## Appendix A – Detailed Record and Response to Submissions

Extracts from Government agency and authority submissions and submissions from the general public received in relation to SSD 10479, and a response to each of these matters, has been outlined in the **Table** below.

<b>Council</b>	Penrith City Council
<b>DPIE</b>	Department of Planning, Industry and Environment
<b>Draft MRP DCP</b>	Draft Mamre Road Precinct Development Control Plan
<b>WSEA SEPP</b>	State Environmental Planning Policy (Western Sydney Employment Area) 2009
<b>The site</b>	200 Aldington Road
<b>FKC</b>	Fife Kemps Creek Pty Ltd

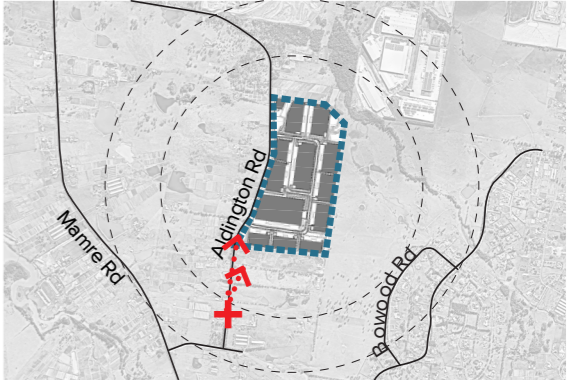
Comment / Extract	Response
<p>The VIA should include viewpoints:</p> <ul style="list-style-type: none"> <li>• along the Aldington Road frontage of the site.</li> <li>• when viewed from Aldington Road at the site's south-western and north-western corners and at the property to the immediate south considering the height of the retaining walls on the site boundary</li> <li>• from the RE2/E2 zoned land in the north-east corner.</li> </ul>	<p>A revised VIA to address the comments raised has been prepared and is provided at <b>Appendix D</b> of the Submissions Report to address each comment raised.</p>
<p>The VIA should include consideration of landscaping, materials, lighting, signage as required in the SEARs.</p>	
<p>The VIA should include photomontages of the development with proposed mitigation measures (e.g. landscaping) to demonstrate the effectiveness of those measures over certain periods (i.e. 1 year, 5 years, 10 years).</p>
